**Project Details** – Land at The Den, Richborough Road, Sandwich

### **Road Safety Audit Stage 1**

This response is to the issues raised in the Stage 1 RSA report, prepared by Road Safety Answers dated November 2023. Ref RSA791

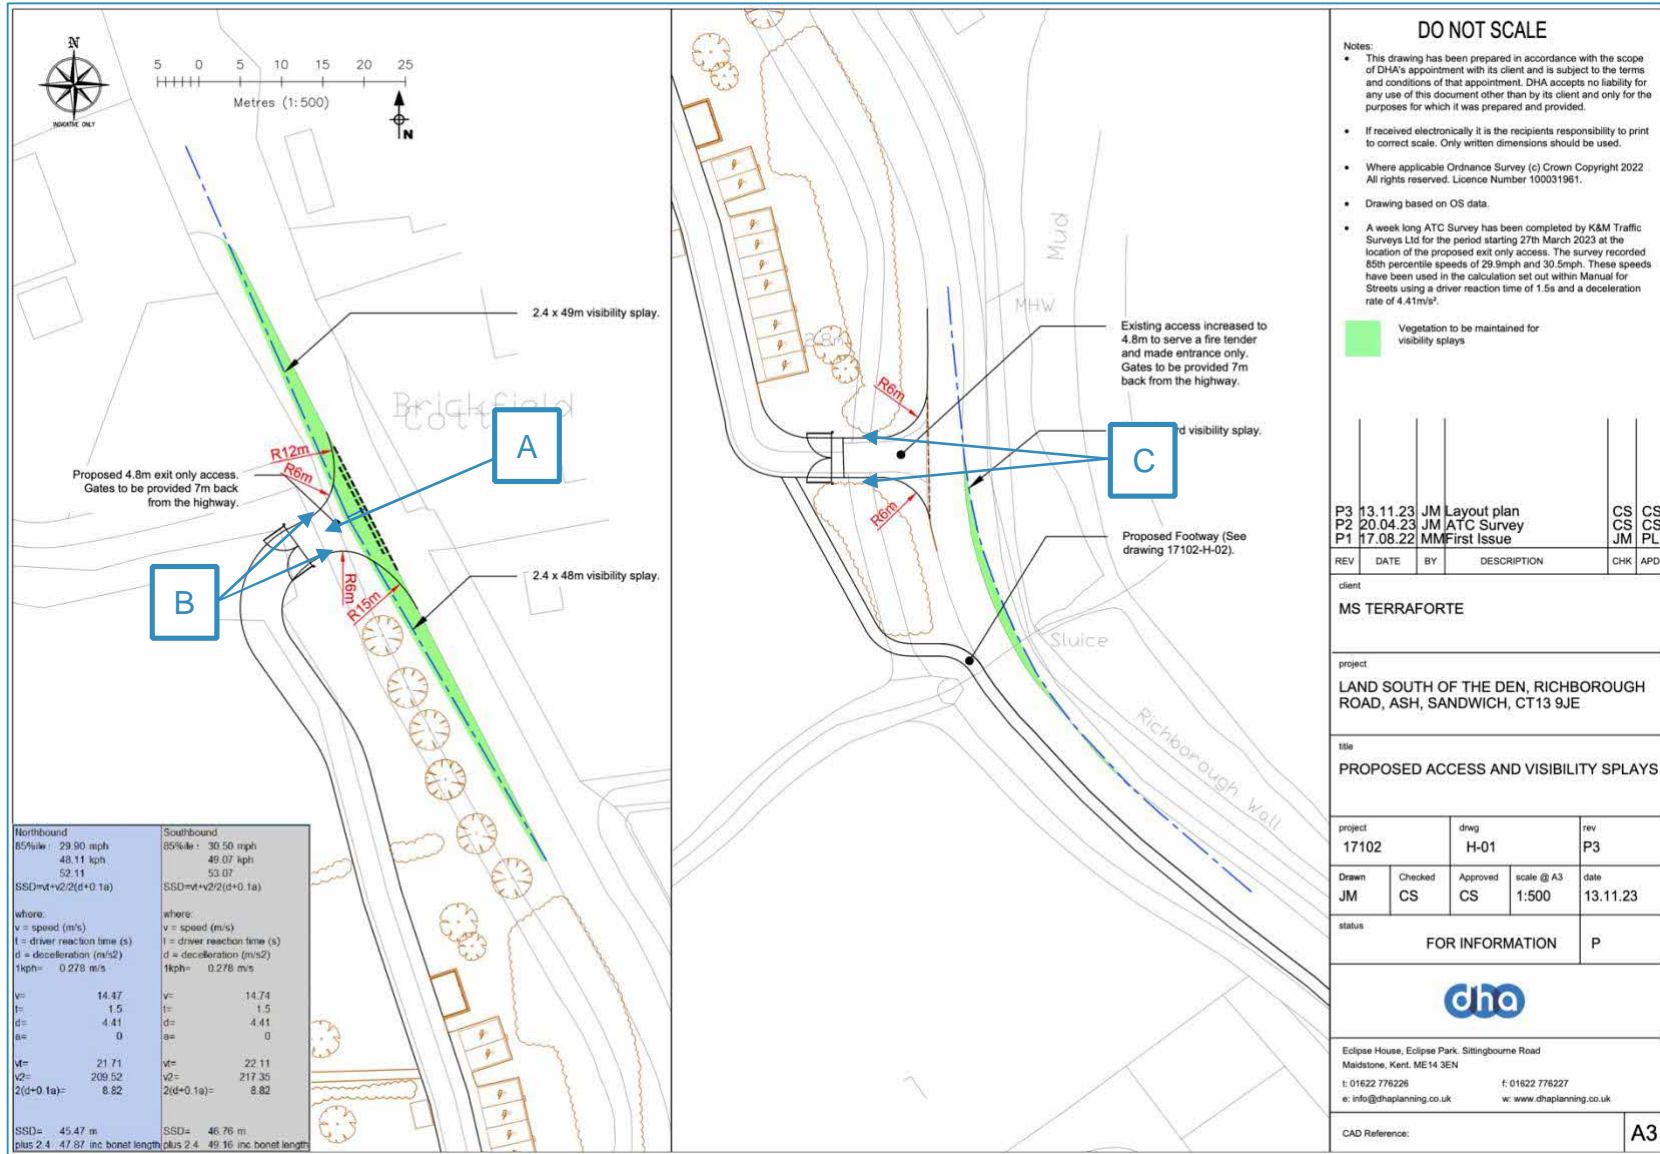
Item Number	RSA Issue	RSA Recommendation	Design Organisation Response	Overseeing Organisation Response	Agreed RSA Action
2.1	<p><b>Location: A</b> - The out-only egress onto Richborough Road (Dwg. 17102/H-01 Rev. P3).</p> <p><b>Summary:</b> Risk of an exiting vehicle rolling back onto a following vehicle.</p> <p>There is currently a gradient up onto Richborough Road of approximately 1 in 8 from the development site. If this is maintained there will be a risk of an existing vehicle rolling back onto a following vehicle, causing damage.</p>	The egress should have a relatively level dwell area approaching Richborough Road.	<p><b>Agreed.</b></p> <p>The access will have a gradient of 1:20 for a distance 12m back from the give way line. Levels will be reviewed further at the detailed design phase.</p>

2.2	<p><b>Location: B</b> – The out-only egress onto Richborough Road (Dwg. 17102/H-01 Rev. P3).</p> <p><b>Summary:</b> Risk of an exiting vehicle falling into the drainage ditch.</p> <p>A relatively deep drainage ditch runs parallel to Richborough Road along the whole frontage of the site. The drawing implies that the exit road will be</p>	The exit road should have protection on each side as it crosses the drainage ditch on the approach to Richborough Road.	<p><b>Noted.</b></p> <p>Vehicles will be going a slow speed when exiting the site so risk is considered a low, however a fence will be provided either side of the access as shown on revised drawing 17102-H-01 Rev P4.</p>

Item Number	RSA Issue	RSA Recommendation	Design Organisation Response	Overseeing Organisation Response	Agreed RSA Action
	<p>kerbed, but does not show any protection to stop an errant vehicle turning off the side of the road into the drainage ditch as it turns the right angle to use the exit. The lack of a protective barrier, wall or verge on each side of the exit road, as it crosses the ditch, increases the risk of a vehicle falling into the ditch, with possible injuries to the vehicle occupants.</p>

2.3	<p><b>Locations: C-</b> The in-only access from Richborough Road (Dwg. 17102/H-01 Rev.P3).</p> <p><b>Summary:</b> Risk of an entering vehicle falling into the drainage ditch.</p> <p>The drainage ditch that runs parallel to Richborough Road along the whole frontage of the site is particularly deep at the proposed access to the site. The drawing implies that the entry road will be kerbed, but does not show any</p>	<p>The access road should have protection on each side as it crosses the drainage ditch next to Richborough Road.</p>	<p><b>Agreed.</b></p> <p>Fences will be provided either side of the access order to provide protection where the access crosses the ditch as shown on revised drawing 17102-H-01 Rev P4.</p>

Item Number	RSA Issue	RSA Recommendation	Design Organisation Response	Overseeing Organisation Response	Agreed RSA Action
	<p>protection to stop an errant vehicle running off the site of the road into the drainage ditch as it turns into the access. The lack of a protective barrier, wall or verge on each side of the exit road, as it crosses the ditch, increases the risk a vehicle falling into the ditch, with possible injuries to drainage ditch next to Richborough Road.</p>

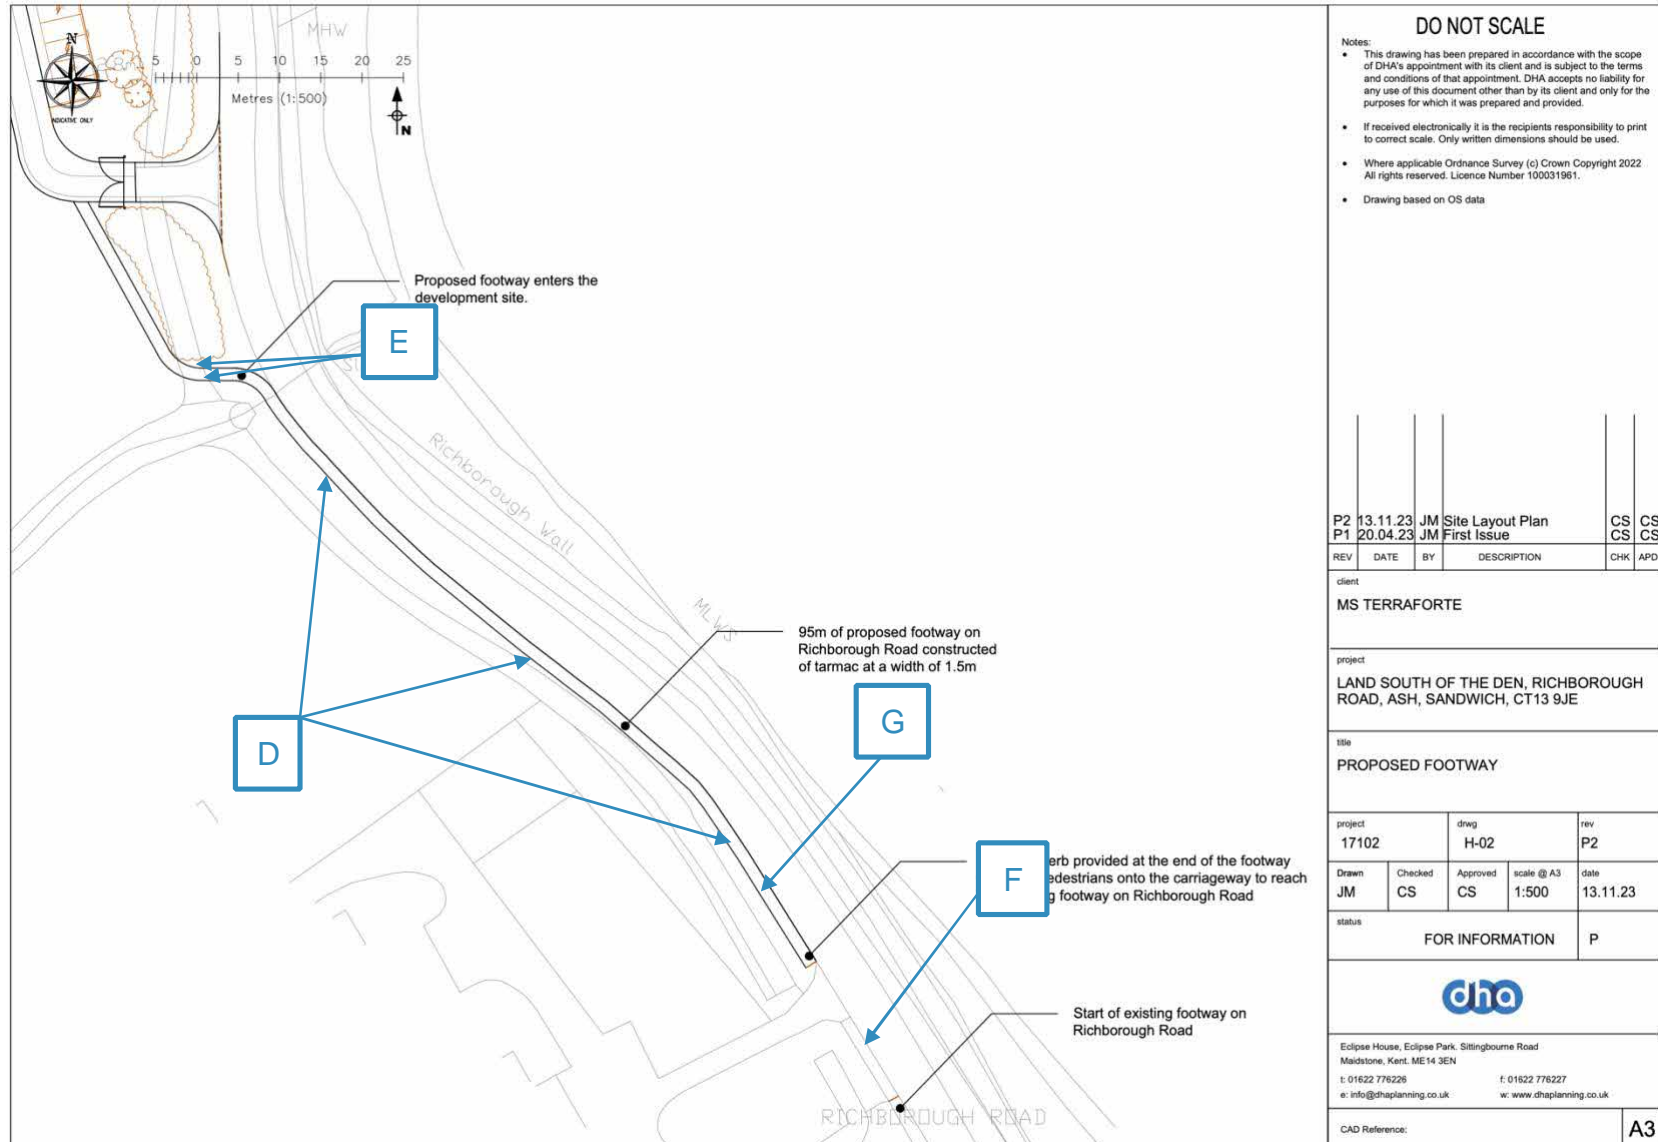
2.4	<p><b>Location: D</b> – The 95m of footway along the verge of Richborough Road (Dwg. 17102/H-02 Rev. P2).</p> <p><b>Summary:</b> Risk of pedestrians falling into the deep ditch.</p> <p>The verge on the west side of Richborough Road falls from what will be the back edge of the proposed 1.5m footway into the deep ditch that runs along this whole stretch of road (photo 1). Without a flat margin behind the footway onto</p>	<p>Measures should be installed to ensure that pedestrians do not fall into the ditch.</p>	<p><b>Agreed.</b></p> <p>A fence line will be provided along the back of the proposed footway as shown in revised drawing 17102-H-02 Rev P3.</p> <p>The form of the fence will be discussed with KCC Highways who will ultimately need to take on maintenance responsibilities.</p>

Item Number	RSA Issue	RSA Recommendation	Design Organisation Response	Overseeing Organisation Response	Agreed RSA Action
	<p>which an errant pedestrian can step, the risk of the pedestrian losing their balance on the slope and falling into the ditch will be unnecessarily high.</p>

2.5	<p><b>Location: E</b> – Northern end of the footway where it enters the development site (Dwg. 17102/H-02 Rev. P2).</p> <p><b>Summary:</b> Risk of pedestrians falling into the deep ditch.</p> <p>As the footway leaves the edge of the carriageway of Richborough Road it will have to bridge across the deep ditch. Without any protection on each side the risk of errant pedestrians falling into the ditch will be unnecessarily high.</p>	<p>Measures should be installed to stop pedestrian falling into the ditch as they cross it on the bridge.</p>	<p><b>Noted.</b></p> <p>The bridge has now been removed so that the footway follows the carriageway.</p>

2.6	<p><b>Location: F</b> – Southern end of the proposed footway (Dwg. 17102/H-02 Rev. P2).</p> <p><b>Summary:</b> Risk of pedestrian/vehicle</p>	<p>The proposed footway should continue southwards to join the existing footway.</p>	<p><b>Agreed.</b></p> <p>The plans have been updated in order to show a connection to the existing footway. There is a telegraph pole that will need to</p>

Item Number	RSA Issue	RSA Recommendation	Design Organisation Response	Overseeing Organisation Response	Agreed RSA Action
	<p>collisions on the carriageway.</p> <p>Pedestrians will have to walk on the carriageway as the proposed footway will stop 19m short of the existing footway (photo 2), increasing their risk of collisions with passing vehicles.</p>		<p>relocated to the rear of t footway.</p> <p>Additionally there are trees within close proximity to the carriageway edge, where there is enough room to provide the footway without the trees removal, the impact on roots will need to be reviewed at detailed design.</p>

2.7	<p><b>Location: G-</b> Towards the southern end of the proposed footway (Dwg. 17102/H-02 Rev. P2).</p> <p><b>Summary:</b> Risk of pedestrian/vehicle collisions.</p> <p>The existing pole with the national speed limit/30mph signs is located in what will be the centre of the proposed footway. If left in situ, mobility impaired users will be unable to pass it on the footway and will have to travel on the carriageway for 120m to use the vehicle entrance to the development side, increasing their risk of</p>	<p>The speed limit pole and signs should be relocated to the verge behind the proposed footway.</p>	<p><b>Agreed.</b></p> <p>The speed limit pole will be relocated to the back of the footway as shown on drawing 17102-H-02 Rev P3.</p>

Item Number	RSA Issue	RSA Recommendation	Design Organisation Response	Overseeing Organisation Response	Agreed RSA Action
	being struck by a passing vehicle.
